Our Ref: TR010036

Date: 07 March 2019

#### **Application by Highways England for an Order Granting Development Consent for the A303 Sparkford to Ilchester Dualling Project**

#### **Application for Additional Land and proposed changes to the original Application**

Drawing Title: **LOCATION OF TEMPORARY WORKS AREAS REQUIRED DURING CONSTRUCTION**

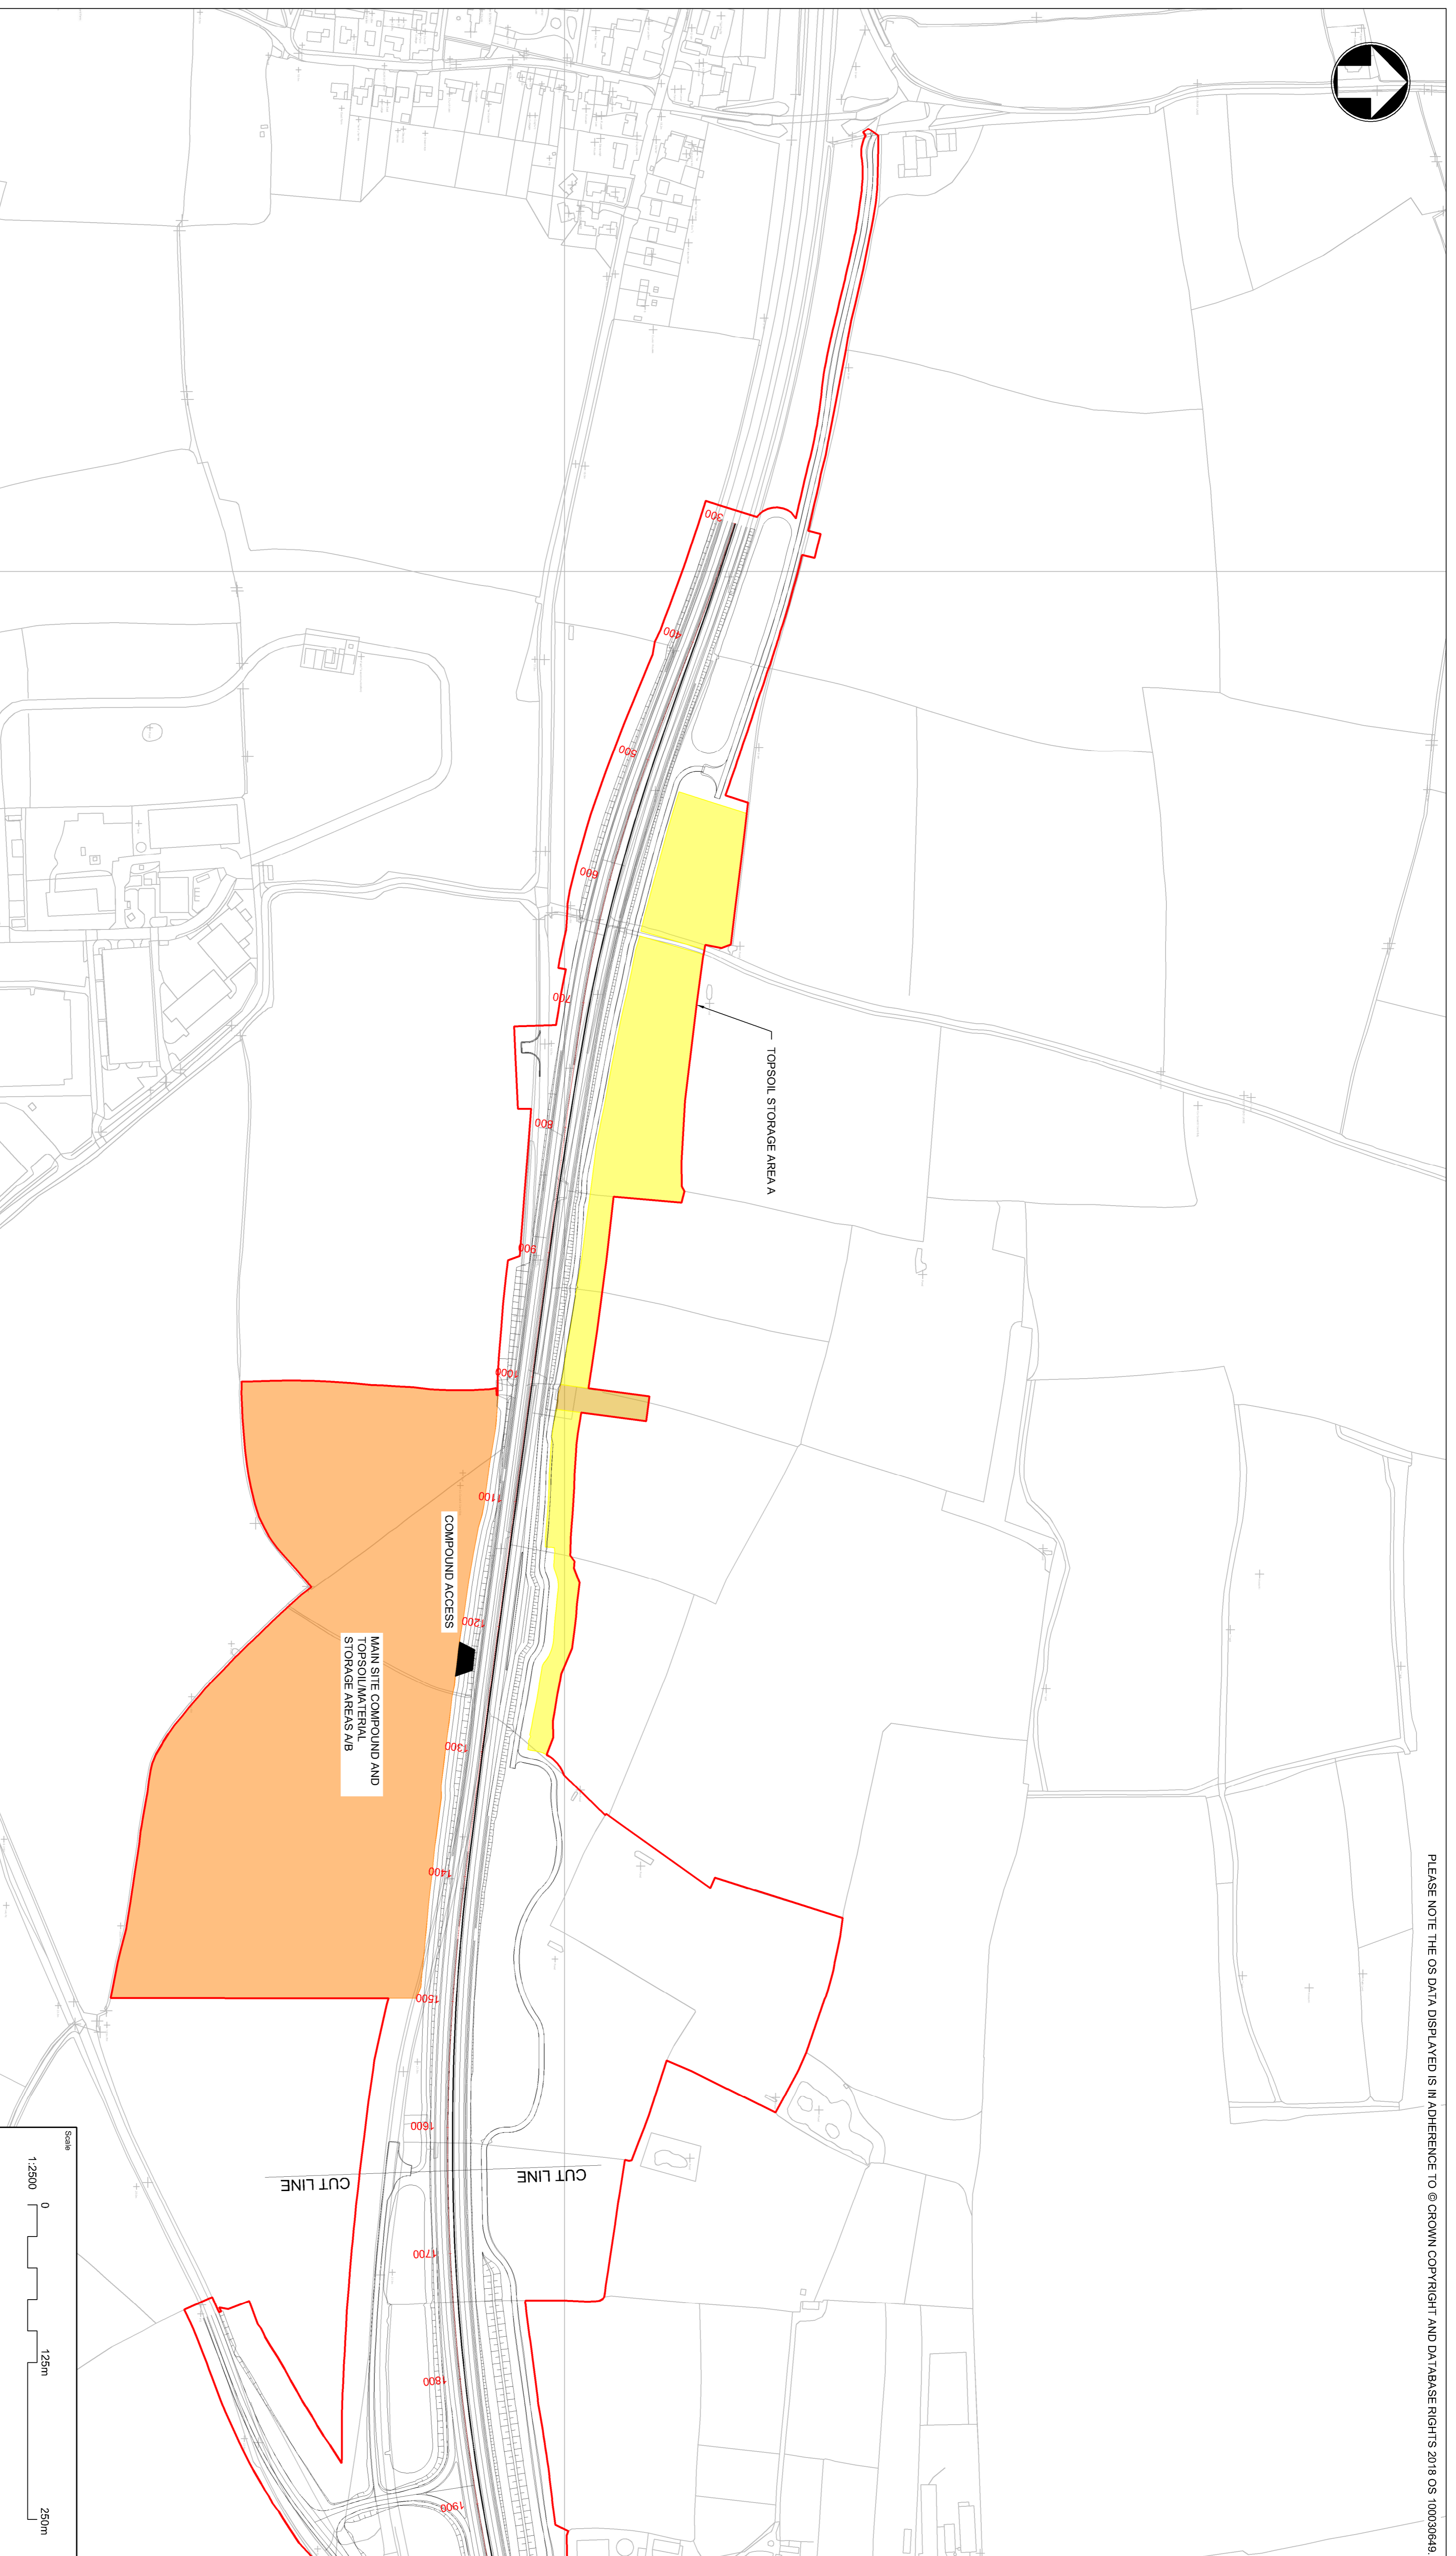
3. ES Addendum Appendix B Figure A2.3, sheet 3 of 4 identifies an area as a site compound. This is shown in the General Arrangements Plan as grassland. Please clarify if this land is intended to be used as a construction compound.
4. Throughout 6.8 ES: Addendum Main Text, Figure A2.3 has been referenced, but the locations referred to are not shown on Figure A2.3 sheet 3 of 4. Can the applicant confirm whether Figure A2.3 should include additional sheets, or whether the reference is to a different plan? It is essential that the correct locations are identified in order to determine whether the assessments have been undertaken correctly.
